CITY OF ALBUQUERQUE

October 27, 2022

Re: Arby's Restaurant
6500 Central Ave. SW
Traffic Circulation Layout
Architect's Stamp 10-05-22 (K11-D095)

Based upon the information provided in your submittal received 10-13-22, the above referenced plan cannot be approved for Building Permit until the following comments are addressed:

A3 ARCHITECTURAL SITE PLAN - TCL  
SCALE: 1" = 20'-0"

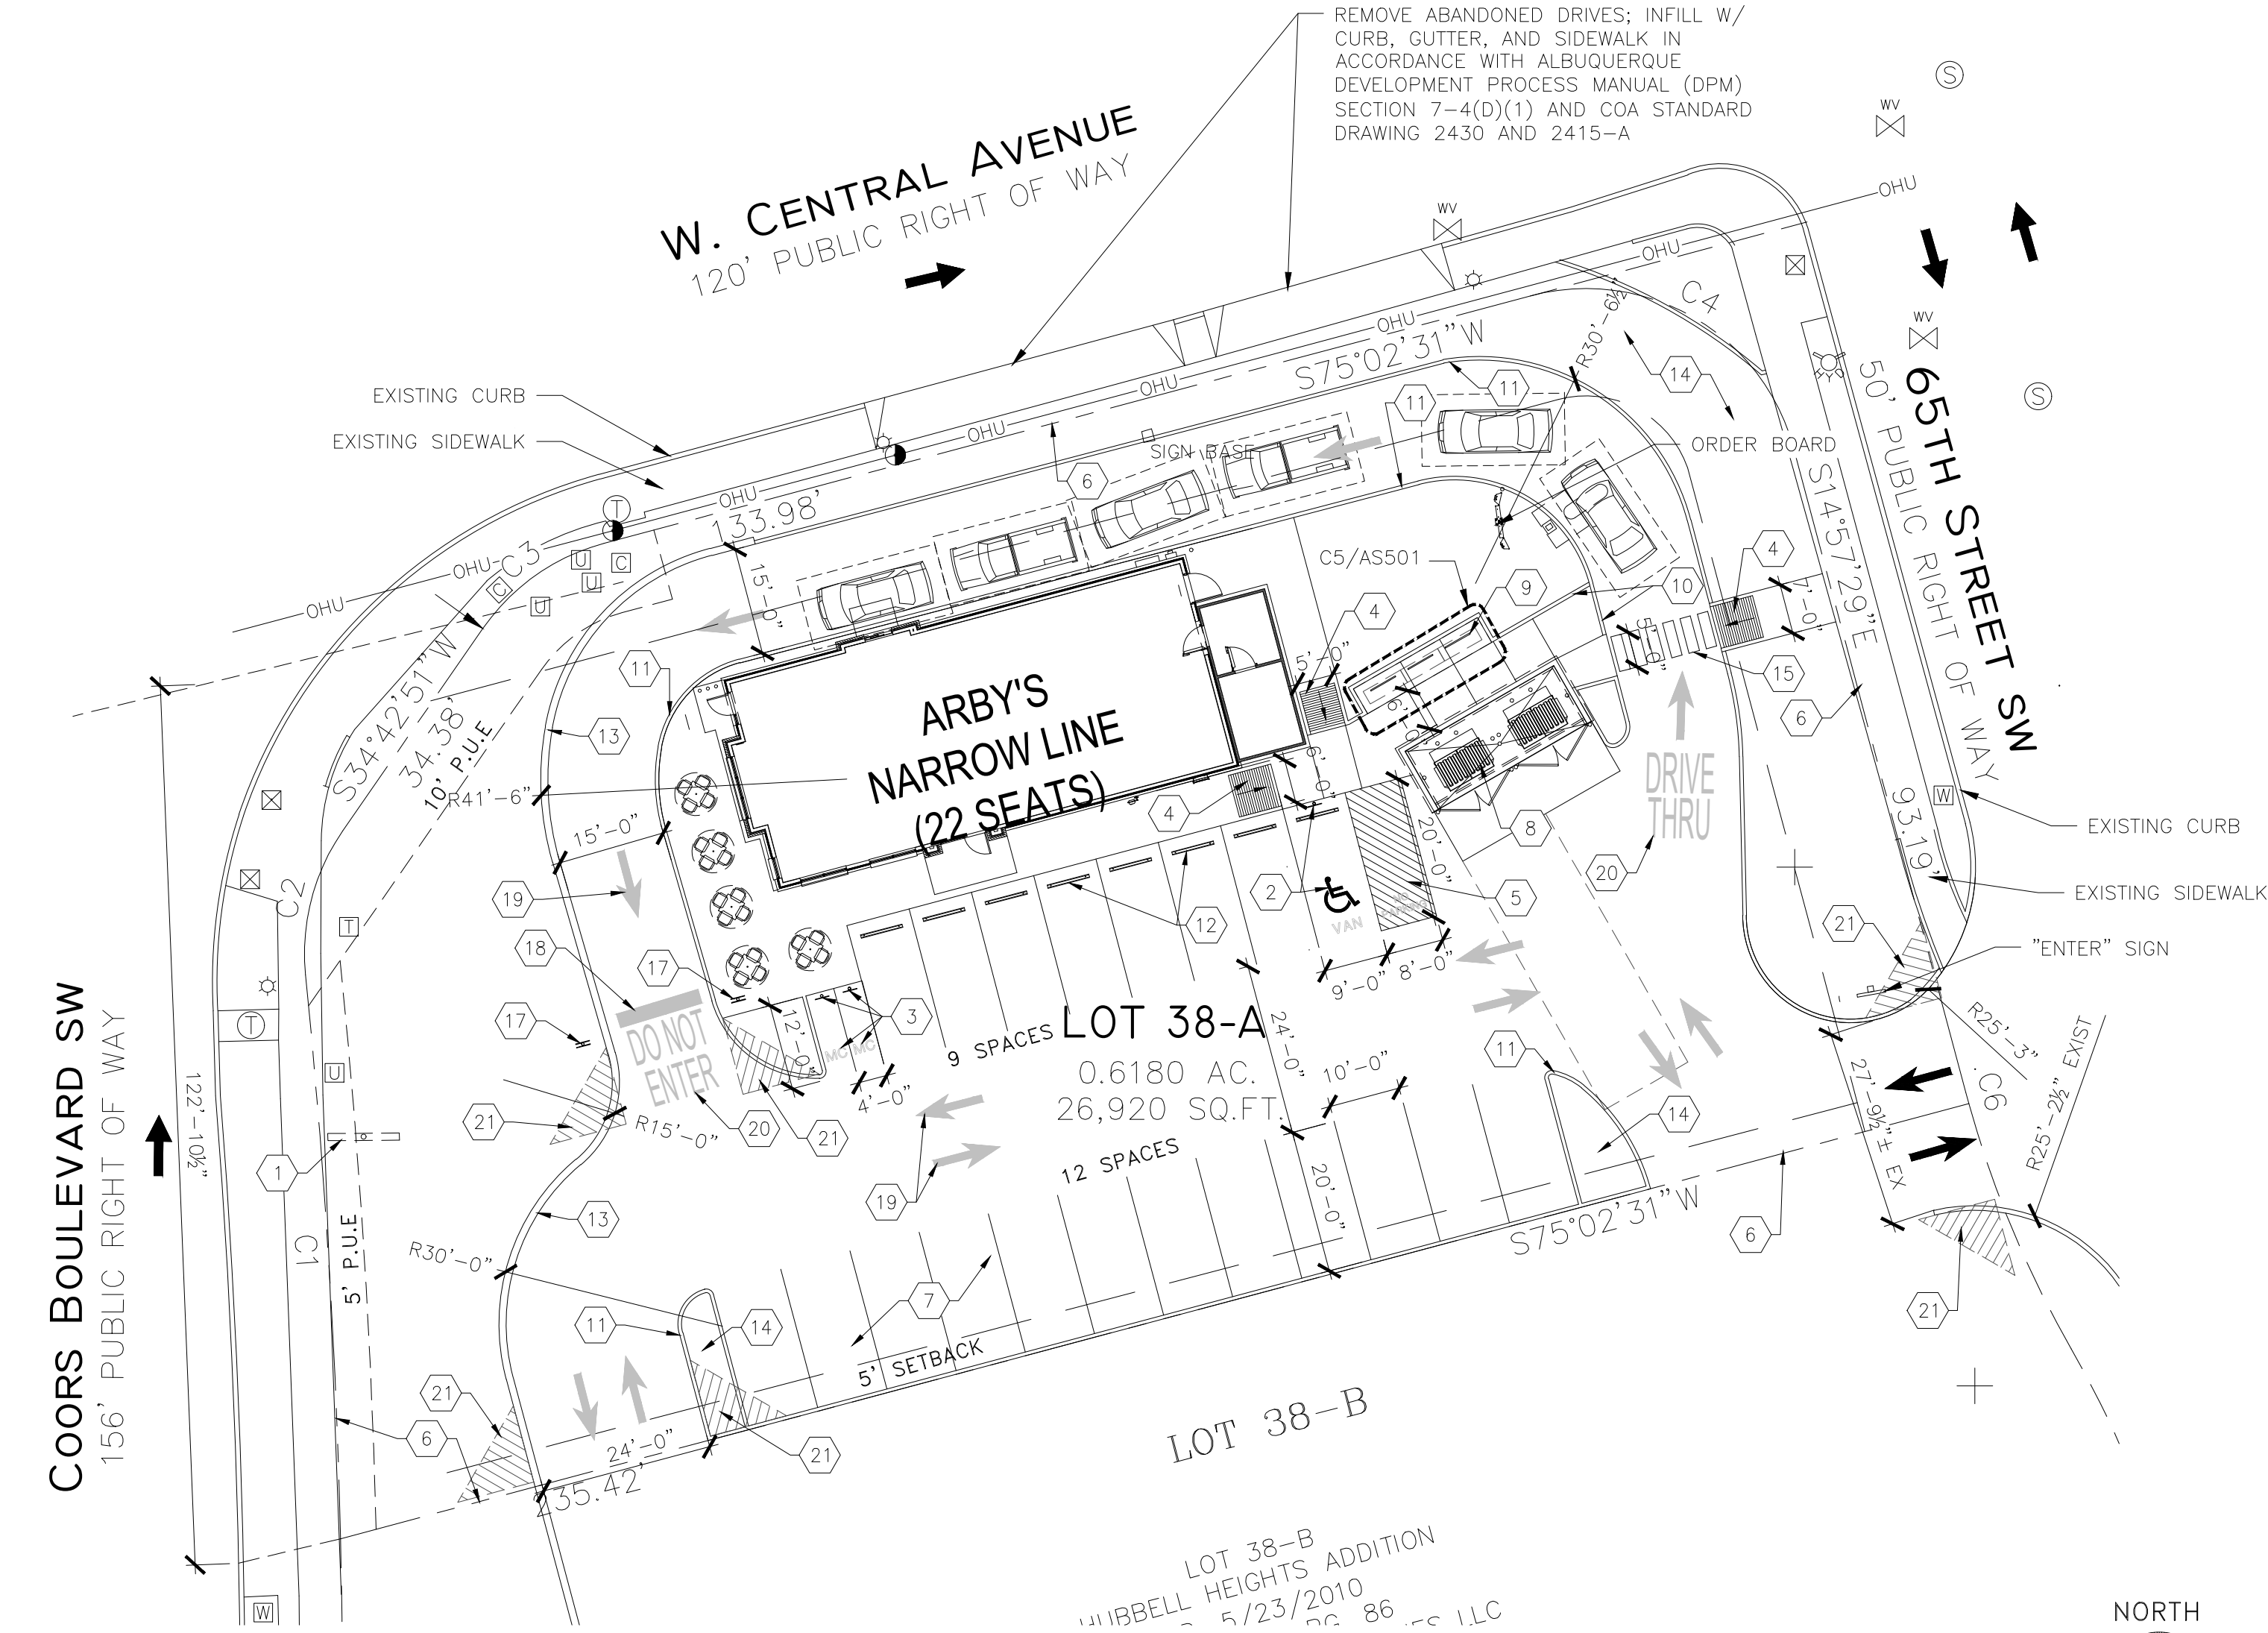
1. Please provide site access driveway width, and the existing access width off 65th St.
2. Shared access agreement between Lot 38-A and 38-B need to be provided. Shared Site access: driveways that straddle property lines, or are entirely on one property but are to be used by another property, shall have an access easement. Please include a copy of your shared access agreement with the adjacent property owner.

3. The ADA accessible parking sign must have the required language per 66-7-352.4C NMSA 1978 **"Violators Are Subject to a Fine and/or Towing."** Please call out detail and location of signs.

4. Motorcycle parking spaces shall be designated by its own conspicuously posted upright sign, either free-standing or wall mounted per the zoning code.

10. The "Do Not Enter" pavement marking should be placed between the land scape island and the motorcycle parking space. "Do Not Enter" and "Stop" sing, should be placed at the same place.

11. Also, please provide "Do Not Enter" and "Stop" sings and pavement marking at the exit of the drive-thru.
12. Details for all the proposed signage and pavement marking need to be provided.

13. Show the clear sight triangle and add the following note to the plan: "Landscaping and signage will not interfere with clear sight requirements. Therefore, signs, walls, trees, and shrubbery between 3 and 8 feet tall (as measured from the gutter pan) will not be acceptable in the clear sight triangle.

14. Clear Sight Triangle need to be shown at the main access off 65th St. and on both site driveways.
15. Please specify the City Standard Drawing Number when applicable.

16. Add a note stating "All broken or cracked sidewalk must be replaced with sidewalk and curb & gutter." A build note must be provided referring to the appropriate City Standard drawing.
